wilbar associates ltd
HIGHWAY CONSULTANTS

Hooks Lane/ Pagham Road (Ref: P/6/17/OUT)

Review of Road Safety Audit Process

A	Tactile Paving adjusted & Hook Lane South Access removed	13/03/17	MRA	BRP
Rev	Description	Date	Initial	Checked

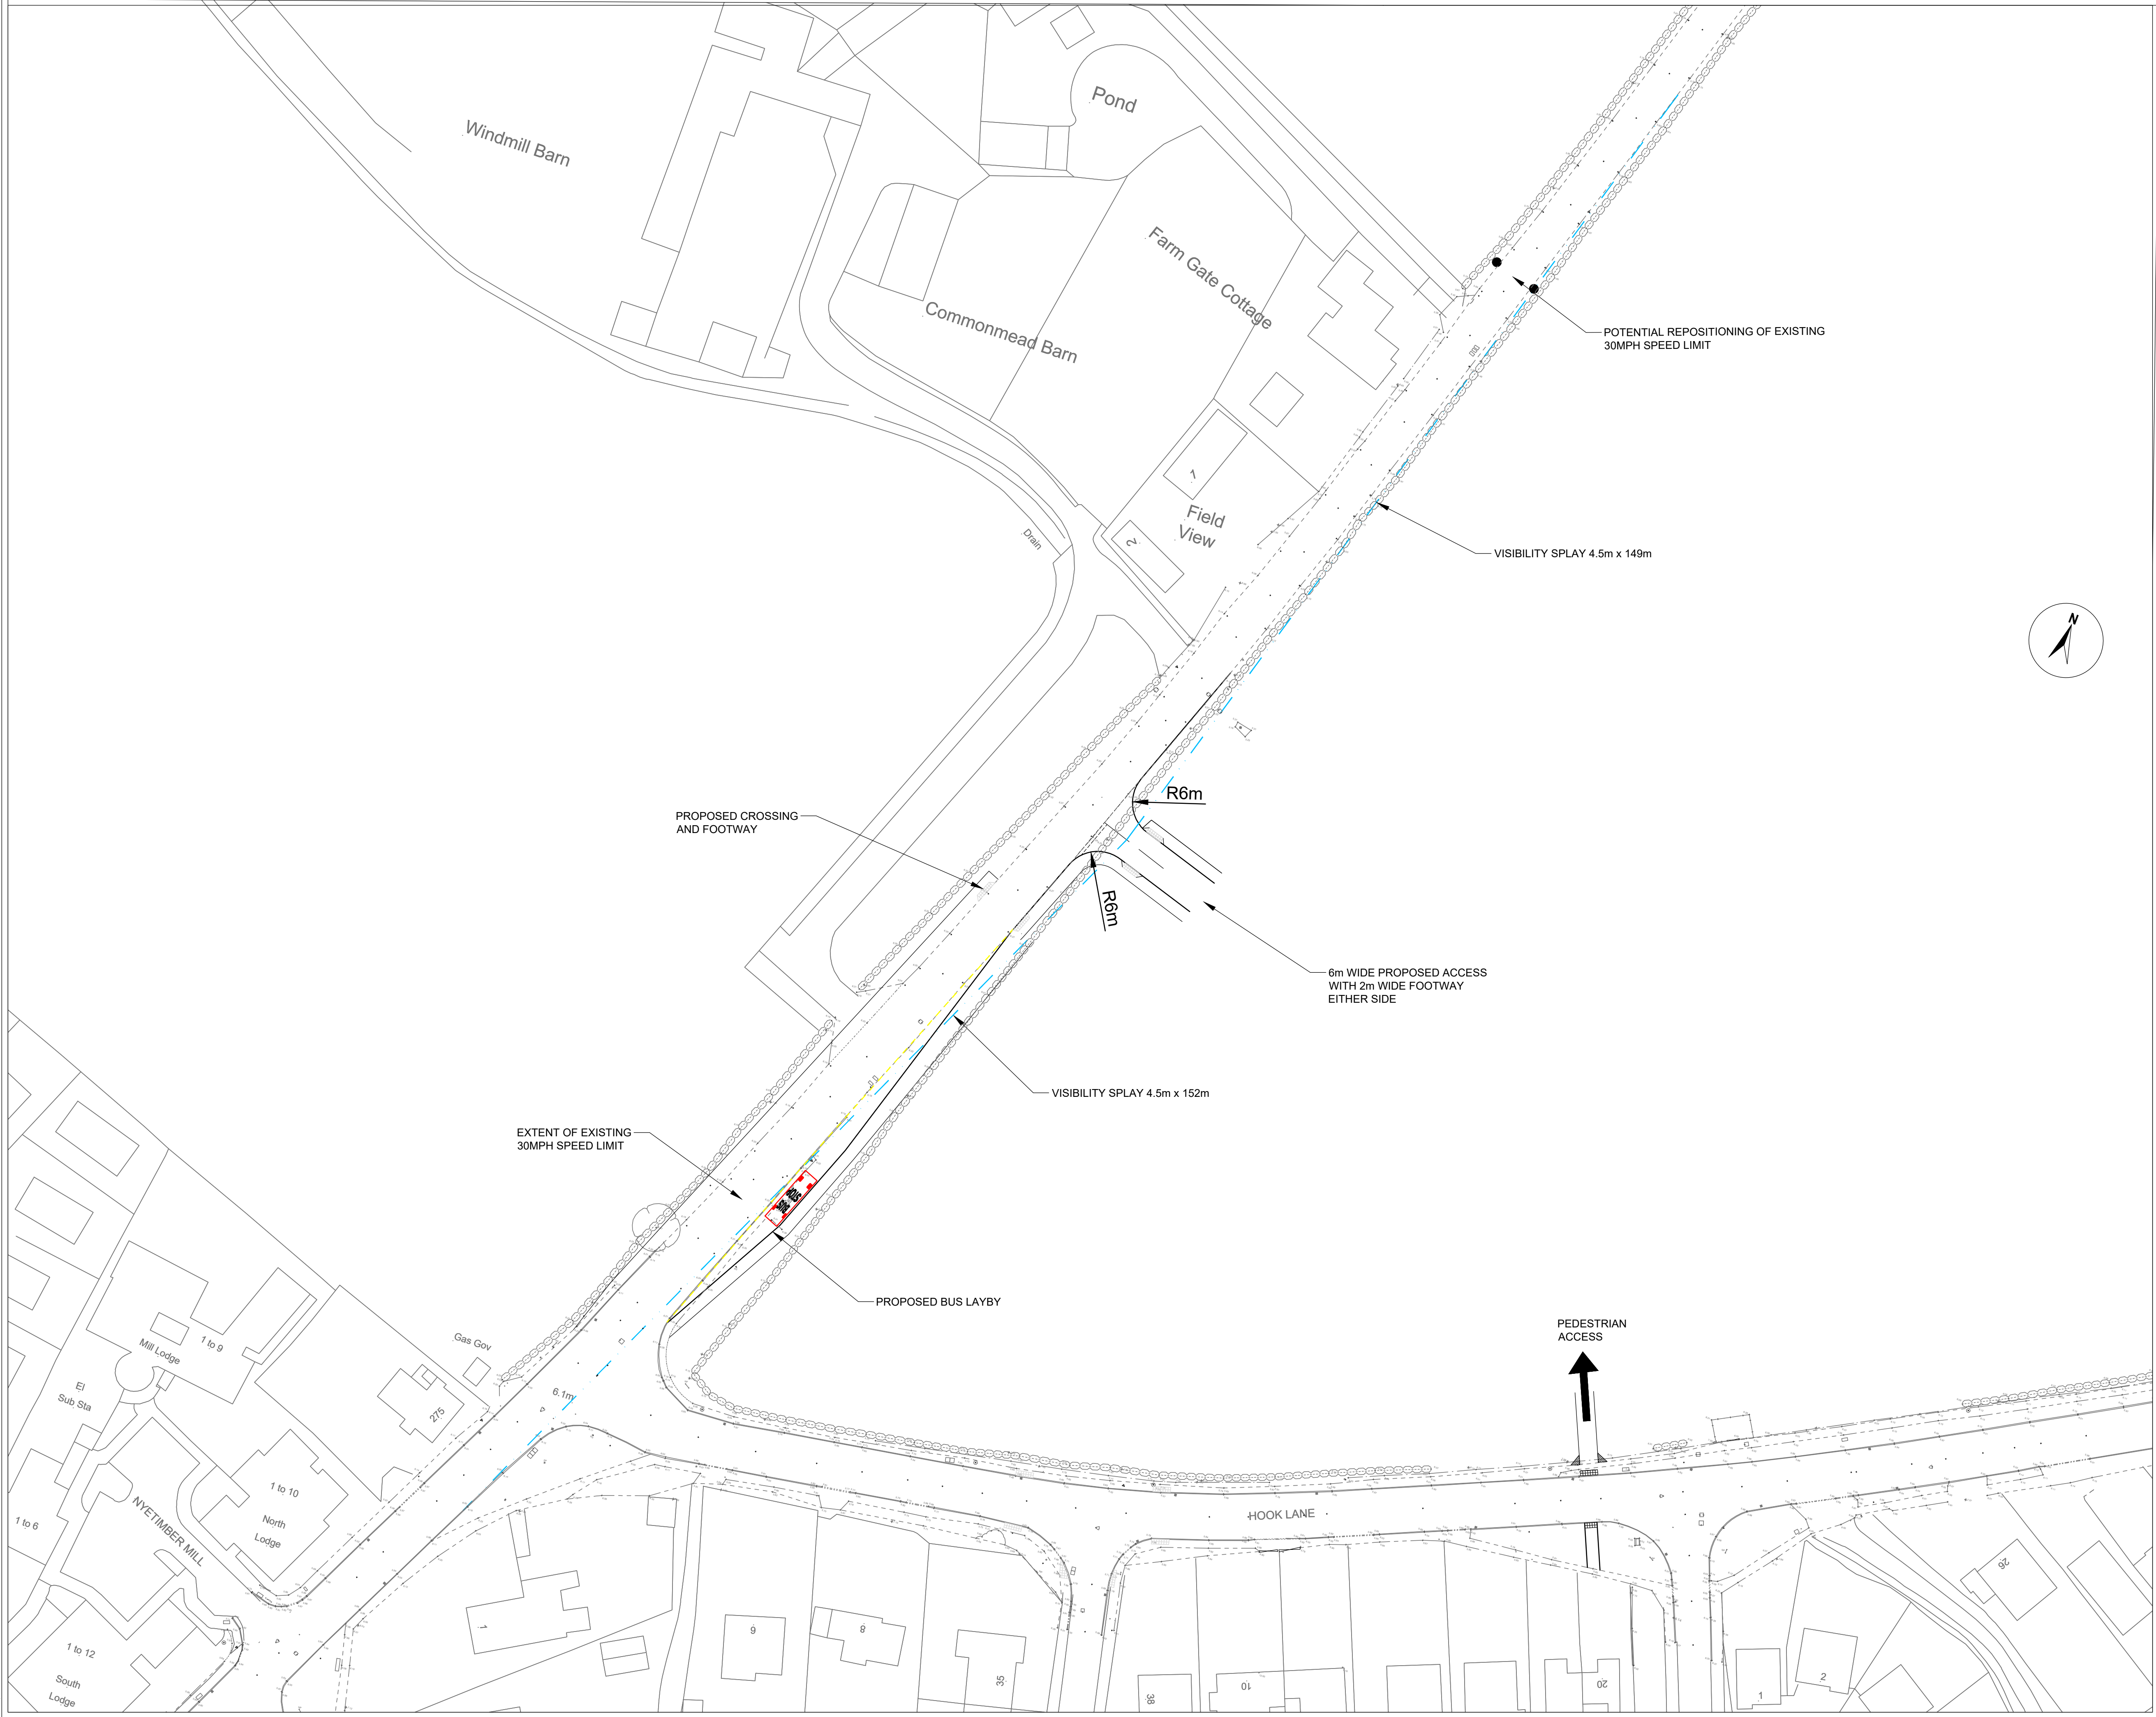
Problem 2.4.2: The scheme proposals indicate that 3 No. pedestrian access points are proposed along the northern side of Hook Lane to/from the development site. However, at this Stage 1 Road Safety Audit, crossing facilities appear to have been omitted entirely Hook Lane to access the pedestrian access points from the footway on the southern side of Hook Lane. Whilst this may be a drafting error at this detailed stage of design, concern arises that this situation could result in a slight detriment to the operational safety for pedestrians, whereby injudicious crossing manoeuvres may be attempted, particularly for those pedestrians who may be blind or visually impaired.	To accommodate anticipated pedestrian movements across Hook Lane to access the proposed pedestrian access points on its northern side, tactile paving onto the proposed flat top facilities should be provided, as appropriate, along Hook Lane. The tactile paving should be located and aligned such that it is on the pedestrian desire lines where possible in-line with DETR Guidance on the Use of Tactile Paving

Problem 2.4.3: At this Stage 1 Road Safety Audit, the scheme proposals indicate that 3 No. pedestrian access points are proposed along the northern side of Hook Lane to/from the development site. The site visit has established that at the 3 No. locations the existing public footway on the northern side of Hook Lane is very narrow. Concern arises that this situation could result in a very slight increased risk of conflicts occurring between pedestrians exiting the development site and those that may be on the existing footway or more importantly of pedestrians stepping straight into the Hook Lane carriageway.	At the design stage of the project, suitable and adequate intervisibility zones should be provided to enable pedestrians to clearly see any passing pedestrians. Associated localised footway vegetation clearance/widening should also be undertaken at these locations in conjunction with Item 2.4.2.

Additional issue raised in December 2016 following design review: It is unclear from the drawing provided whether the original flat-top hump feature that was proposed at this location will be relocated to where the access junction was originally proposed i.e. swapped over. The original scheme proposals included vertical traffic calming measures at regular intervals along the length of Hook Lane, which would likely achieve good speed compliance. The removal of a vertical traffic calming measure (in the vicinity of Lodsworth Road) would leave a length of carriageway where vehicular speeds could increase with the associated risk to pedestrians and other vulnerable road users.	It is recommended that if the proposed access road is relocated further north that a separate flat top hump should be added in the vicinity of Lodsworth Road to ensure that consistent speeds are achieved along Hook Lane.

Summary of Issue Raised	Response to recommendation.
Problem 2.1.1: Summary: Lack of drainage could result in potential surface water ponding issues with a resultant impact upon the operational safety of the proposed highway works.	Accept recommendation, at detail design the drainage for the proposed arrangement will be provided.
Problem 2.2.1: Summary: Reducing the potential for overtaking within the ghosted right-turn facility area, which could result in a potential increased risk of vehicular conflicts occurring.	<i>Following discussions with WSCC LHA the right turn lane at the junction has been removed and replaced with a priority junction. [Authors comment]</i>
Problem 2.4.1: Summary: Accommodating anticipated pedestrian desire lines throughout the proposed highway works.	Accept recommendation, tactile paving has been provided on the proposed access arrangement.
Problem 2.4.3: Summary: Potential lack of adequate and suitable inter-visibility could result in a very slight increased risk of conflicts occurring between pedestrians.	The proposed pedestrian accesses will be a minimum of 3m wide and as such it is considered that this is more than sufficient to provide adequate visibility for pedestrians. The appropriate visibility splays for pedestrians is identified on the proposed access plans.
